HINCKLEY NATIONAL RAIL FREIGHT INTERCHANGE

Project reference TR050007

Applicant's response to deadline 3 submissions [Part 3 - LCC]

Document reference: 18.13

Figure 2: Revised Furnessing Methodology

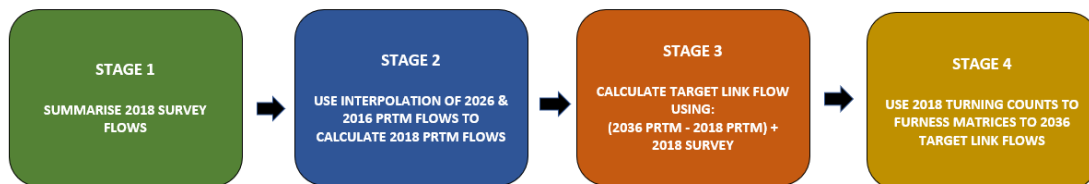
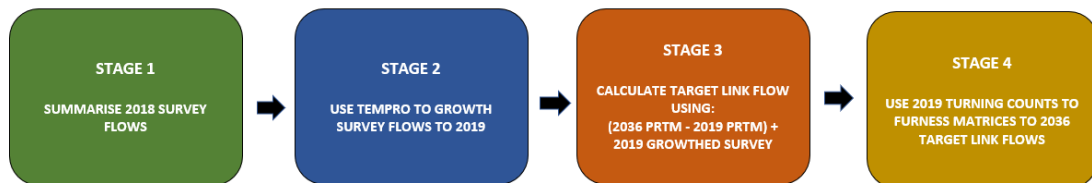
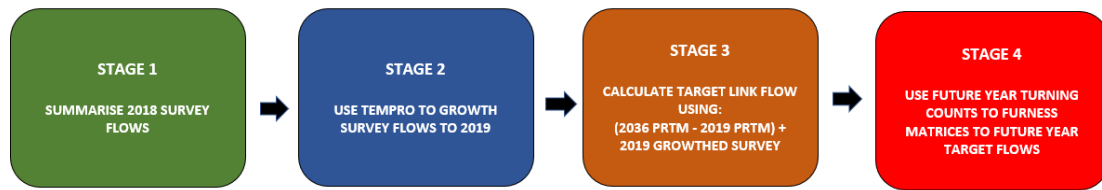
4	(iv) Agenda item 3e: Furnessing: LCC does not dispute the methodology used by the Applicant. However, the PRTM does not validate for turning movements, and survey data is required for this process. The Applicant is relying on data from 2017. LCC is concerned with the age of the traffic data use to inform the furnessing process. There has been an opportunity post pandemic, certainly post 2021, to review turning movements against updated survey data. There have been changes to the network and in respect of committed development the effect of which needs to be captured.	Further discussion with the TWG was held on 13/11/23 during which it was agreed that the furnessing methodology had been accepted by the respective authorities. Further surveys were carried out in late November on the mitigation junctions to further update the furnessing outputs, this analysis has been set out in the Transport 2023 Update (document reference: 18.13.2).

5	LCC would like to see the surveys and furnessing updated. Travel patterns and turning movements have changed significantly. Indeed, the network has changed in that period which plainly influences turning movements. Without appropriate up to date data, the Applicant may be designing to flows/movements that are no longer occurring in the same way as six years ago.	As above at response 4.
6	(v) Agenda item 3f: Padge Hall Farm: LCC explained that the uncertainty log in PRTM was agreed in 2021. In March 2023 there were resolutions to grant planning permission for the Padge Hall Farm development. LCC understand that the issue of the planning	Following a further meeting on the 13/11/23 post hearing, it was agreed with the TWG authorities that the Padge Hall VISSIM will be updated with outputs from the HNRFI PRTM model run and this is included in the Transport 2023 Update submitted at deadline 4 (document reference: 18.13.2)..

BRIDLEWAY UNDERPASS GENERAL ARRANGEMENT
SCALE 1:500

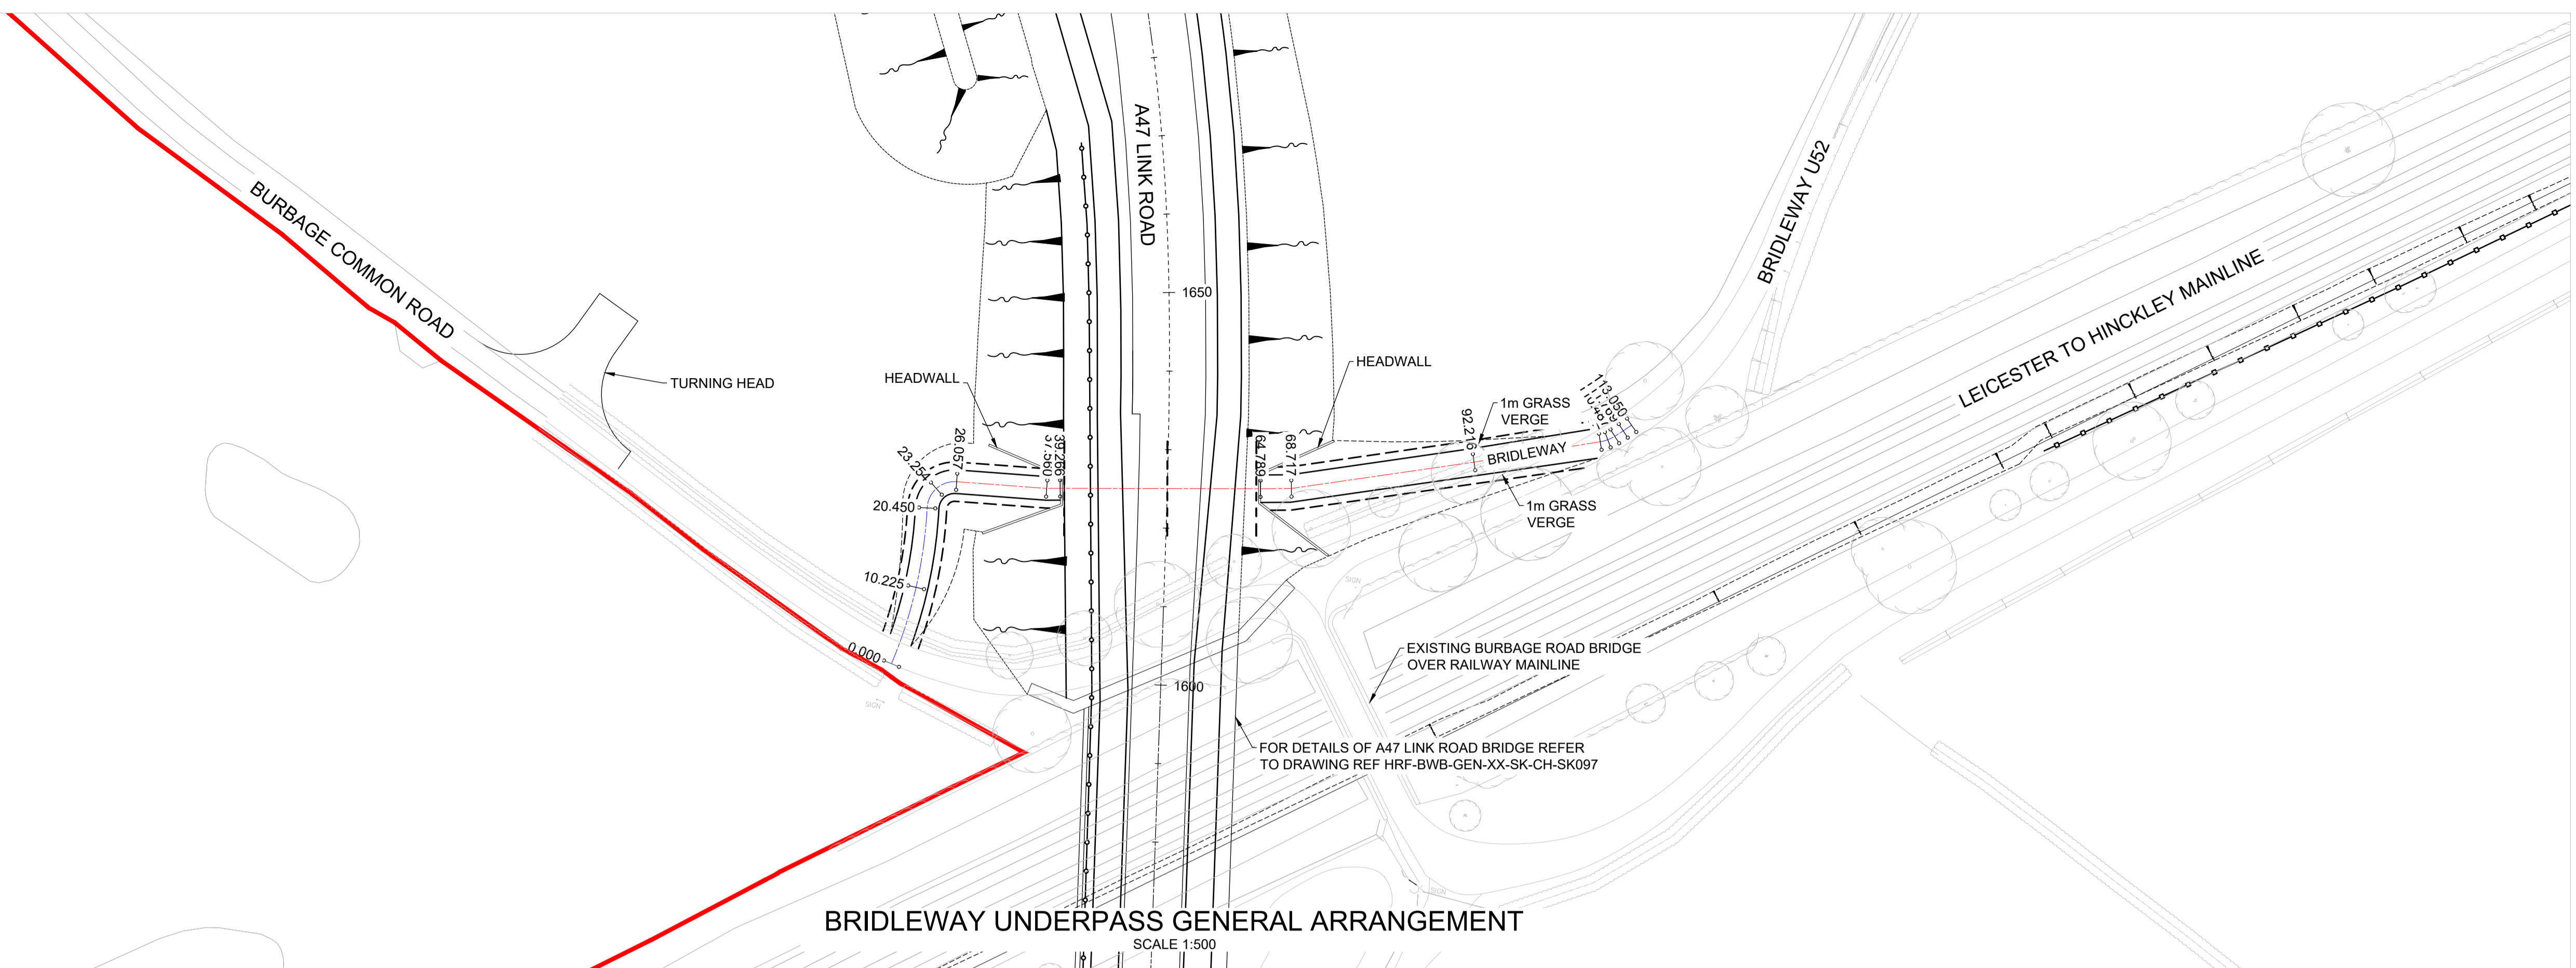
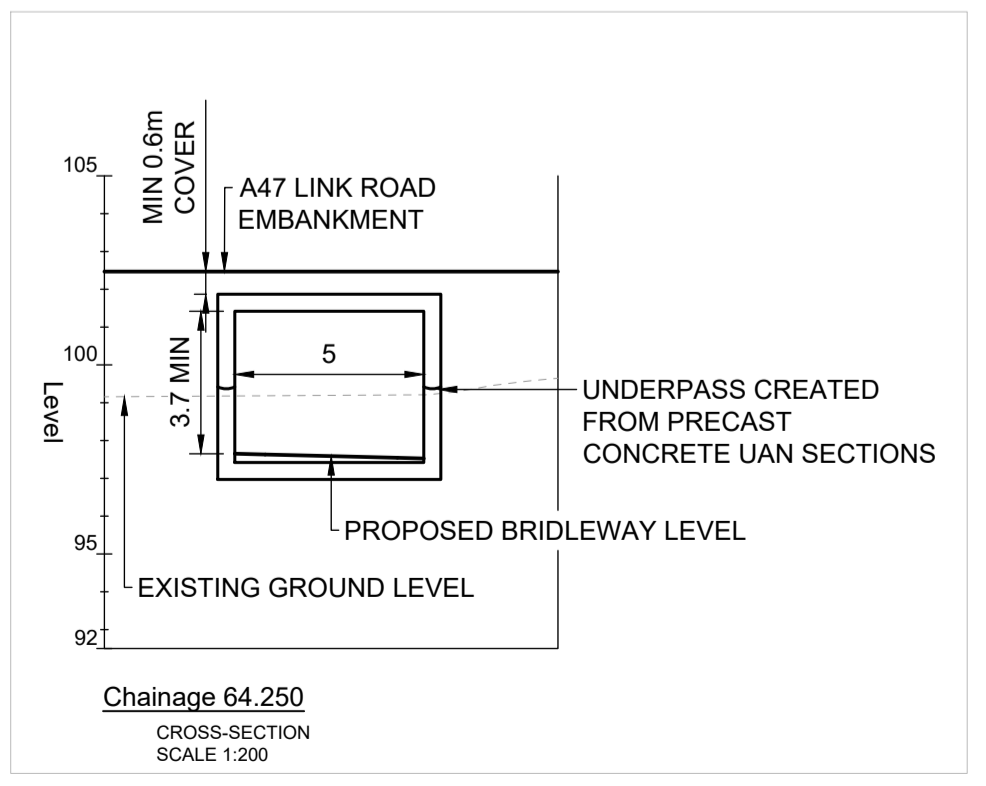
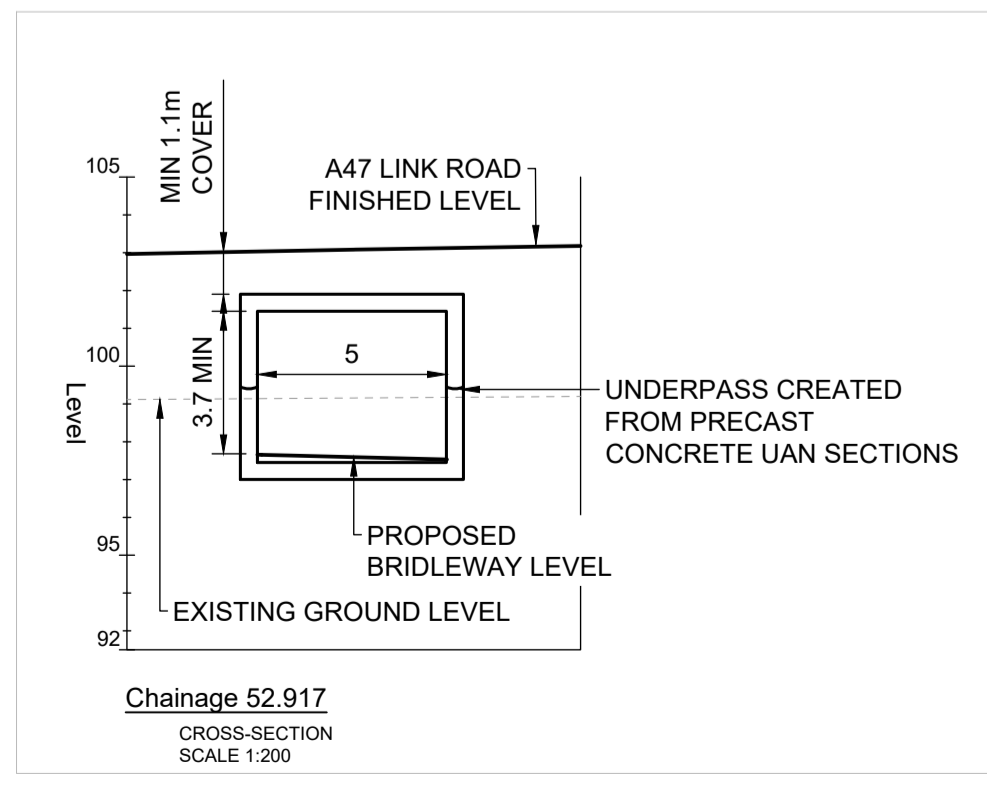
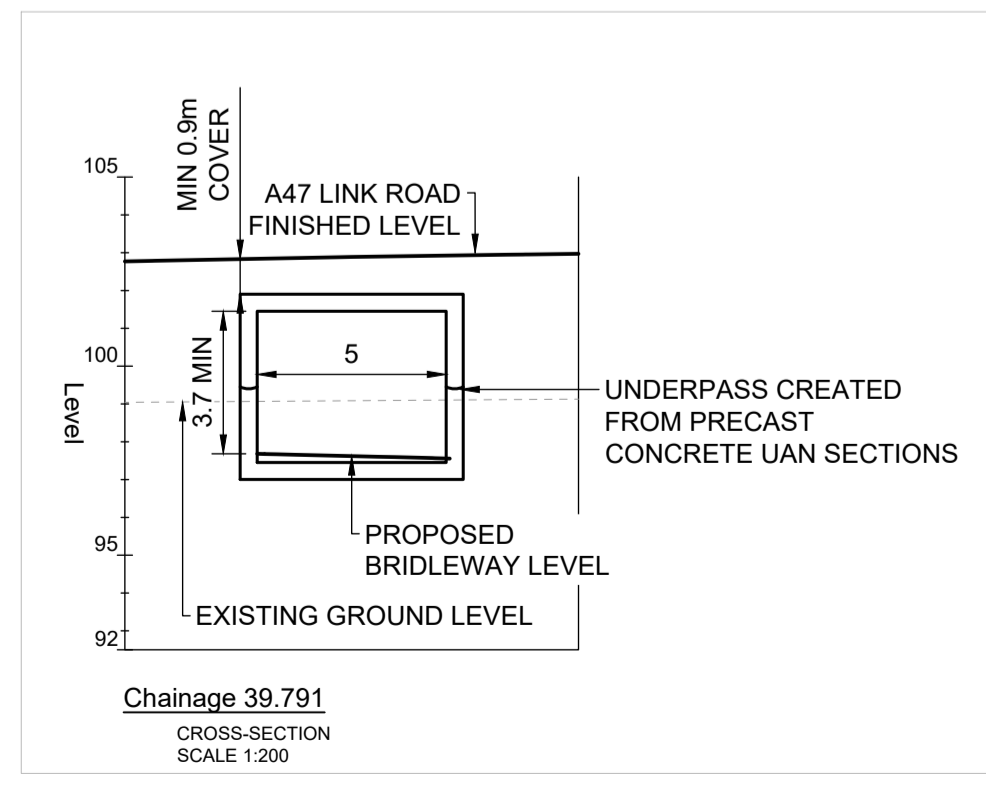
REP2-006 Hinckley NRFI Bridge Plan – S1-P06	
36	The plan (REP2-006) as submitted does not address LCC concerns in respect of gradients, and how PROW U52 and the access to Bridge Farm will tie in with the link road for all users, nor does the elevation drawing include for the underpass. It also appears that the proposed footway/cycleway deviates in its width. We await the submission of further information, including 1:500 drawings, by the Applicant at Deadline 3.	1:500 plans of the link road were submitted as appendices to the Geometric Design Strategy Record submitted at Deadline 3 (document reference 2.29, REP3-005). Further meetings with LCC enabled the applicant to explain the connection between U52 and the link road as well as agreeing with LCC that cross sections through the new PROW around the boundary of the site at several locations would be produced to demonstrate the available width and how this interfaces with the surrounding infrastructure.
